From: Alan Unsted [REDACTED]
Sent: 25 April 2019 11:05
To: Sian Eggington
Subject: 20 Tangmere Gardens Aldwick - Planning application ref: AW/114/19

Floor plans

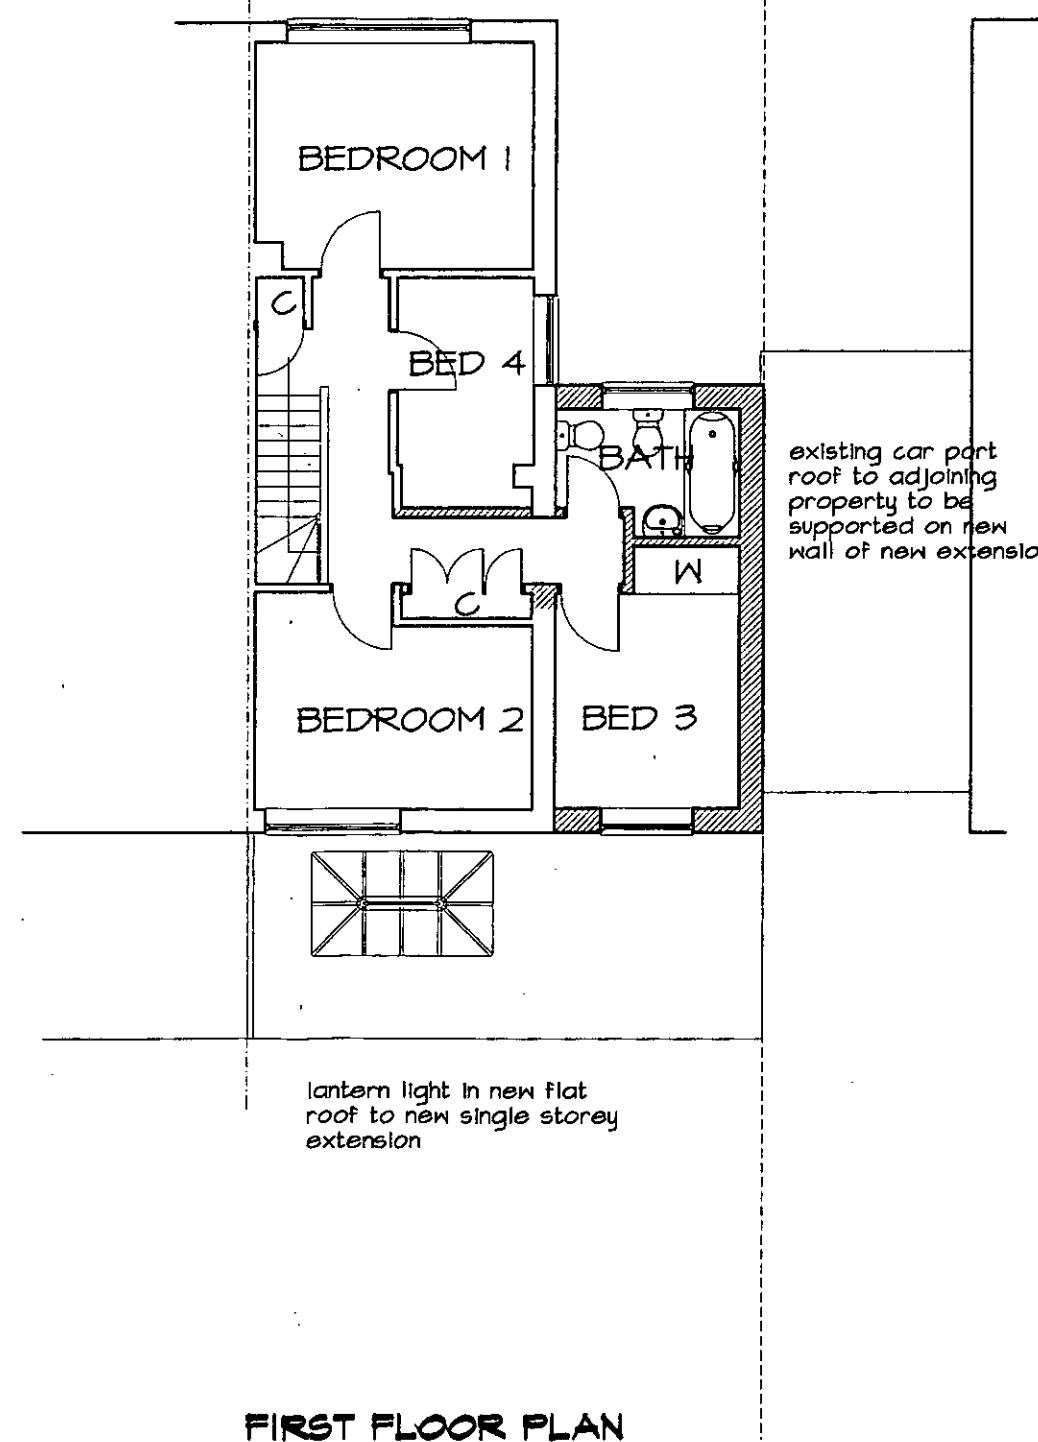
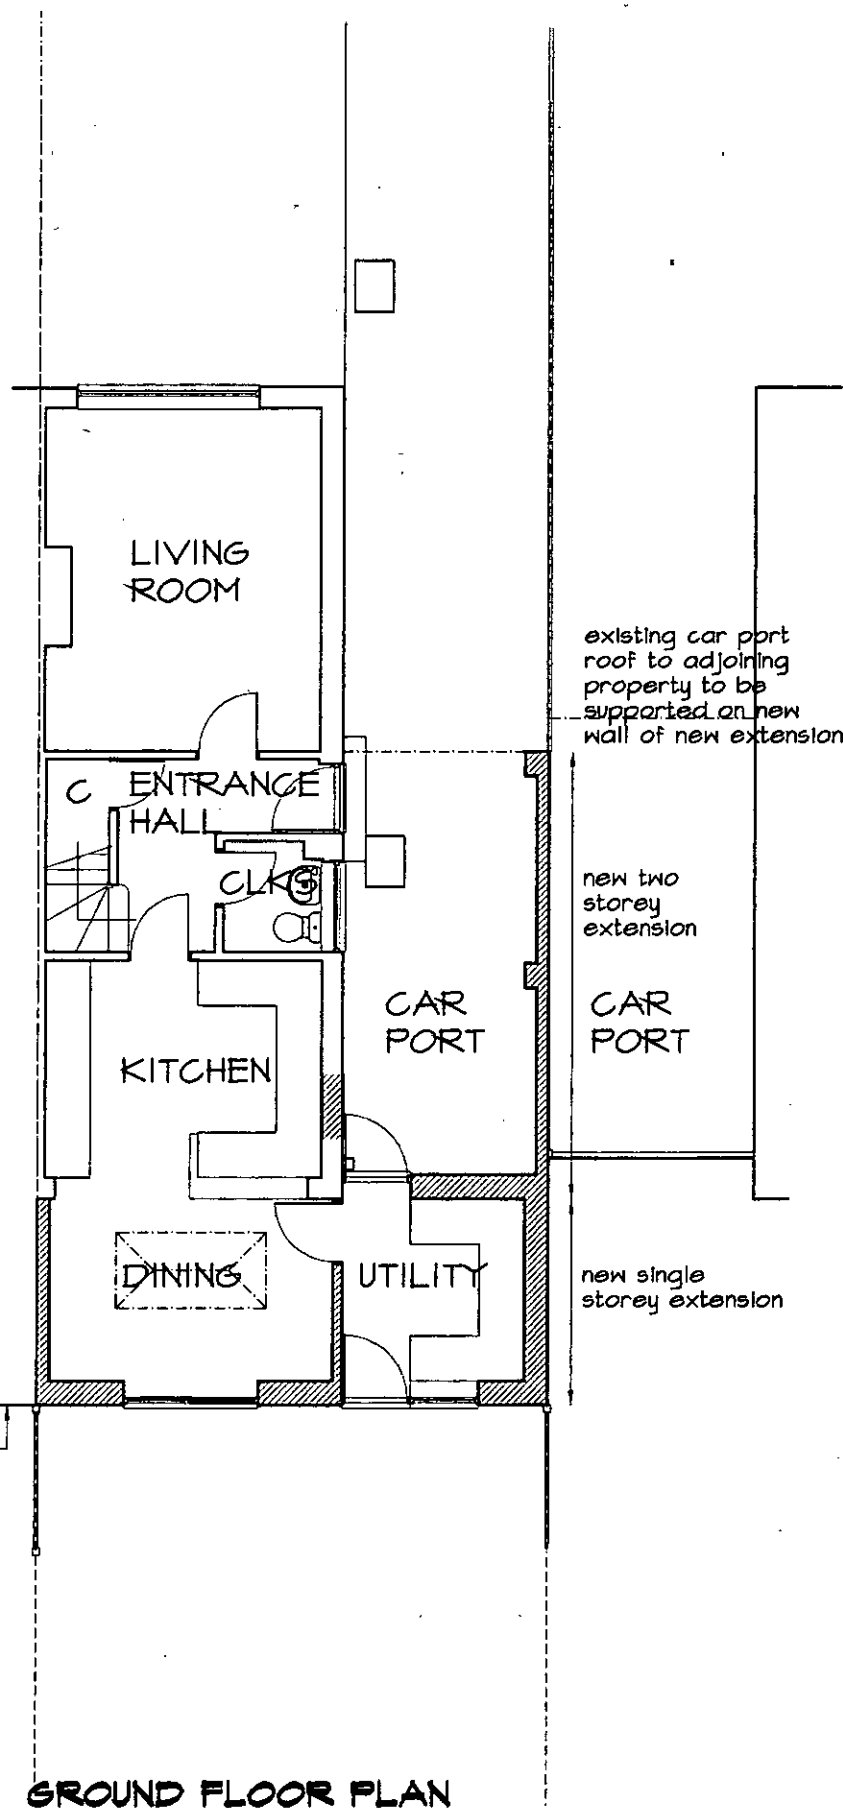
There is already an existing carport on the side of this building which the new side extension will be constructed over maintaining the existing carport space. Therefore the answer to question 8 on the form is correct.

SITE PLAN - scale 1:500

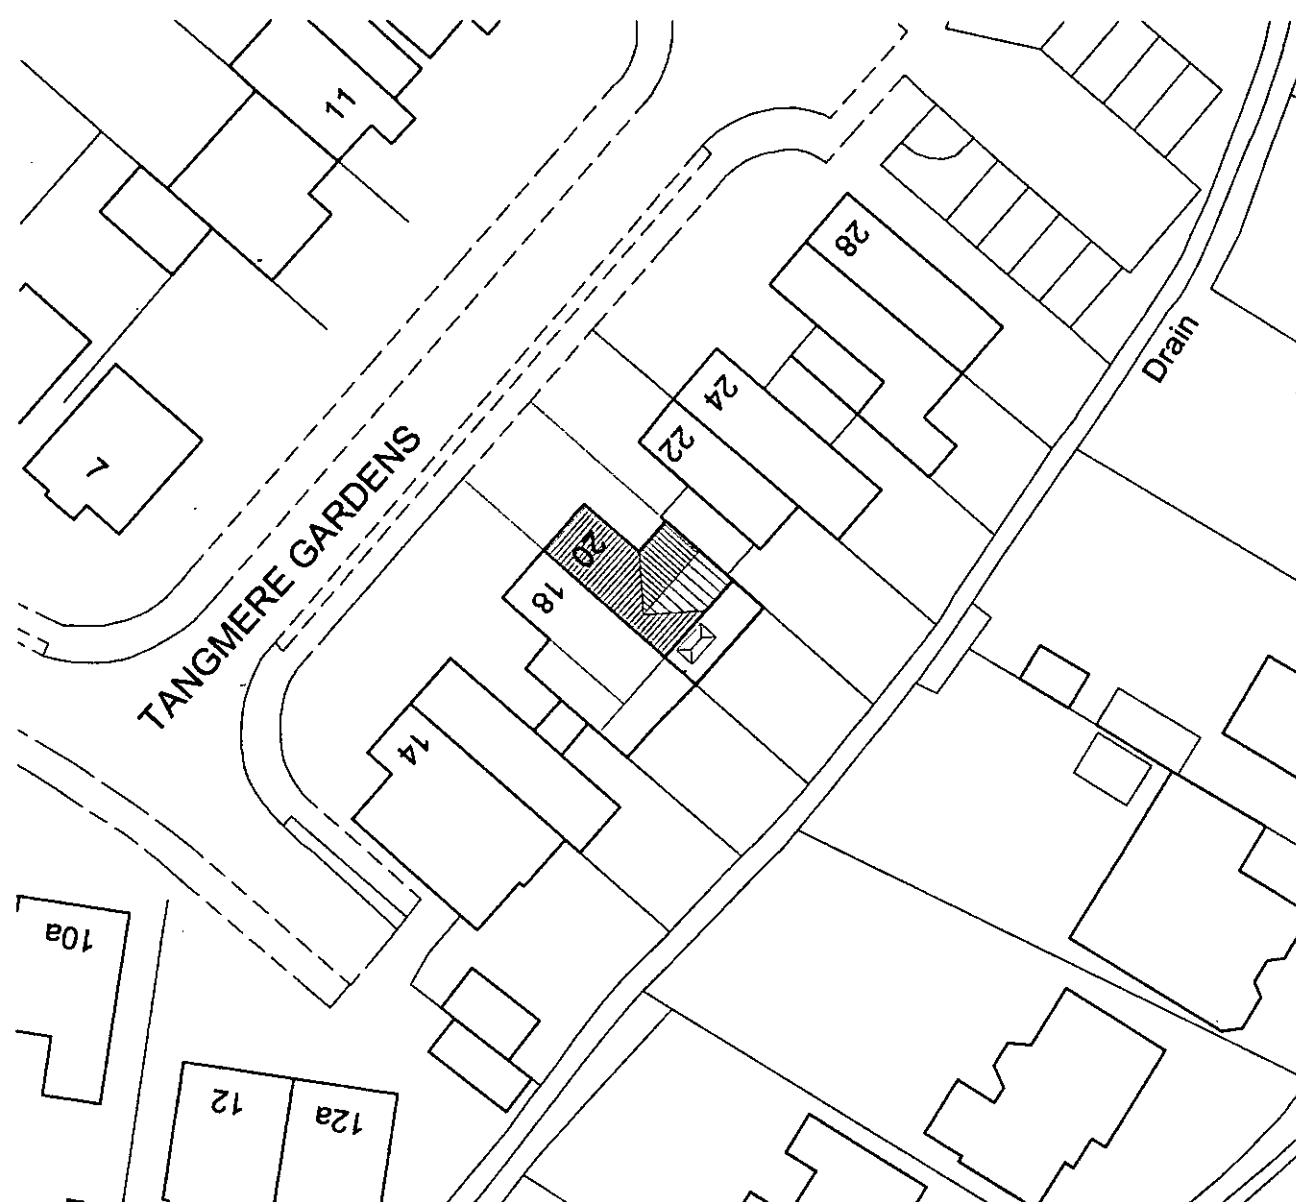
With reference to your letter of today's date, I can confirm the additional information you require as follows:-
Block Plan.

The distance from the front of the side extension to the front boundary is 12 metres.

The distance from the face of the rear extension to the rear boundary is 9.7 metres.
